**22/01682/F**

**Land North Of Manor Farm Noke**

**Development of a ground mounted solar farm incorporating the installation of solar PV panels, associated infrastructure and access, as well as landscape planting and designated ecological enhancement areas.**

These additional comments are in response to the submission of further information in March 2023:

Fence Elevation

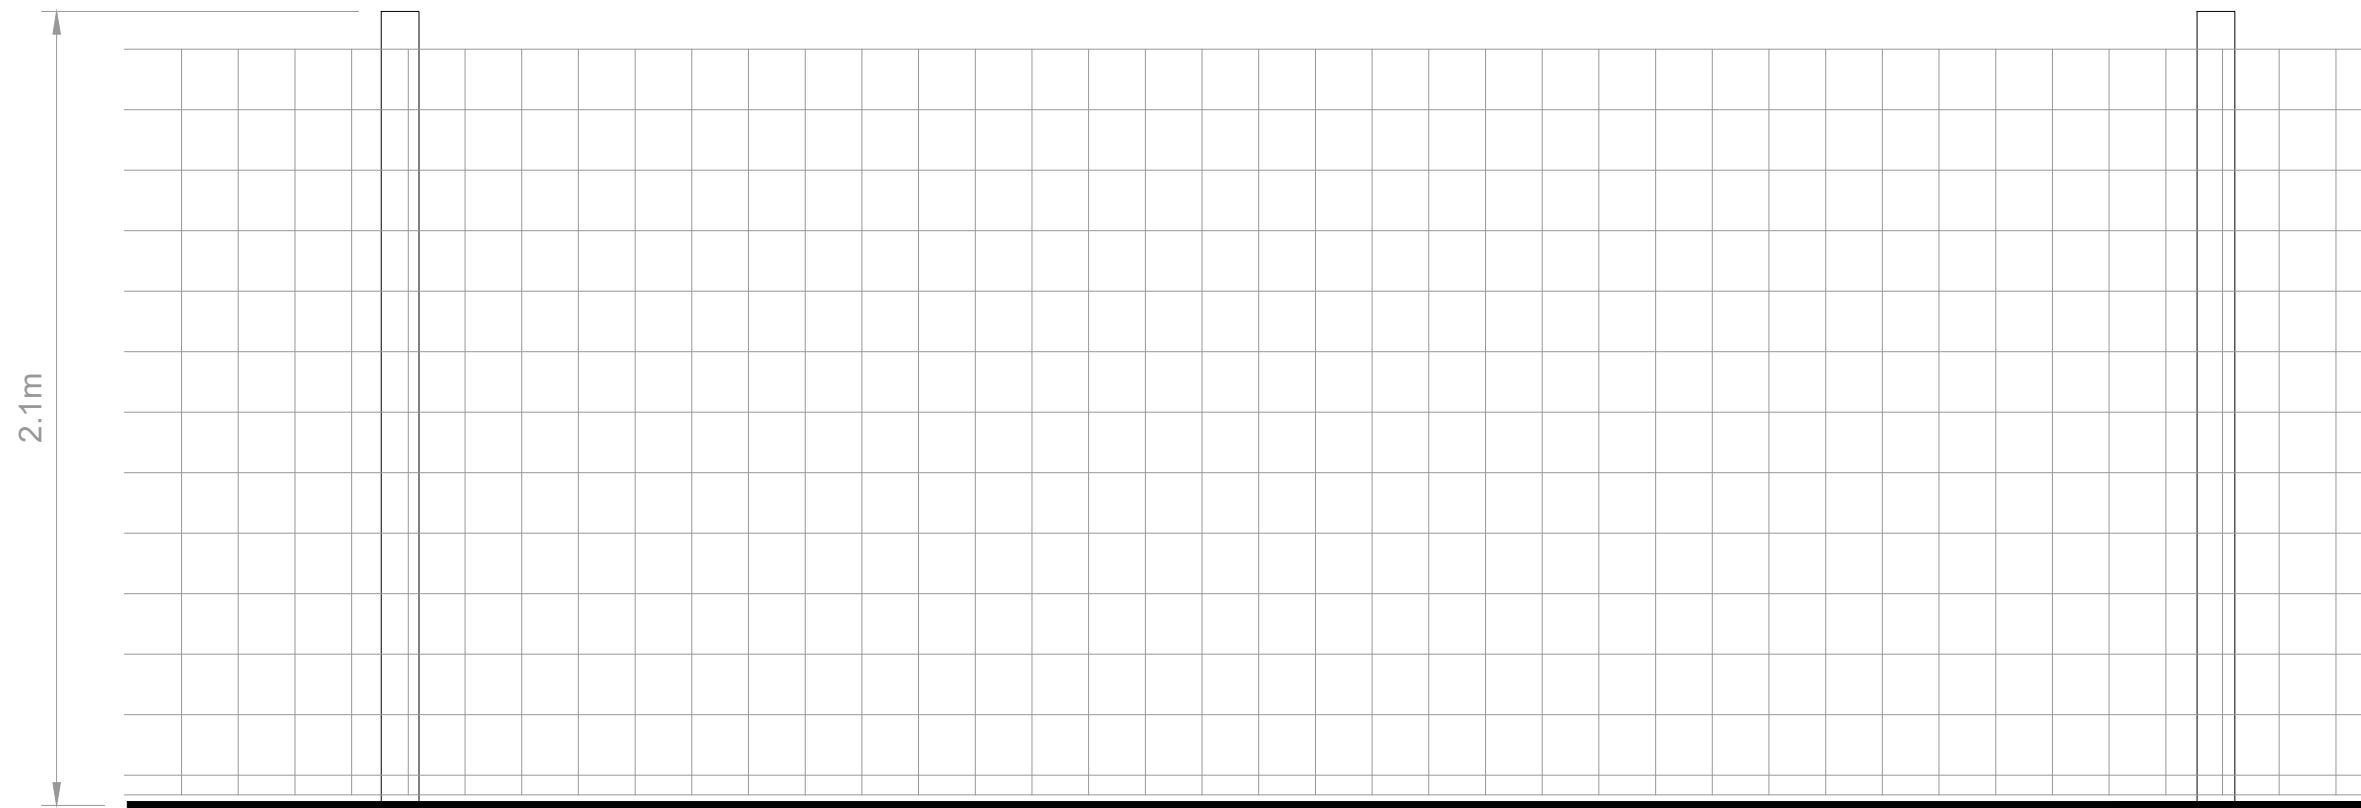
***Impact on Otmoor Local Wildlife Site / RSPB reserve - collision of birds with security fencing***

We maintain our position as stated in our first response (see below). We consider that a security fence of such height presents a significant collision risk to low-flying birds. It also represents a considerable impact on connectivity to many types of wildlife. We consider that no security fence should be used in such a sensitive location. **We therefore maintain our objection on this matter.**

- The removal of the proposal for tall security fencing. The application includes plans for security fencing 2.1m in height. This is likely to present a significant collision risk to low-flying birds, that would be of particularly high risk in the proposed location bearing in mind the proximity to Otmoor and the fact that birds would be taking off or landing on Otmoor with flight paths that may put some of them at risk from the security fencing. The fencing would also have significant impacts on the movement of some mammal species. We therefore consider that in this location no security fencing should be used.
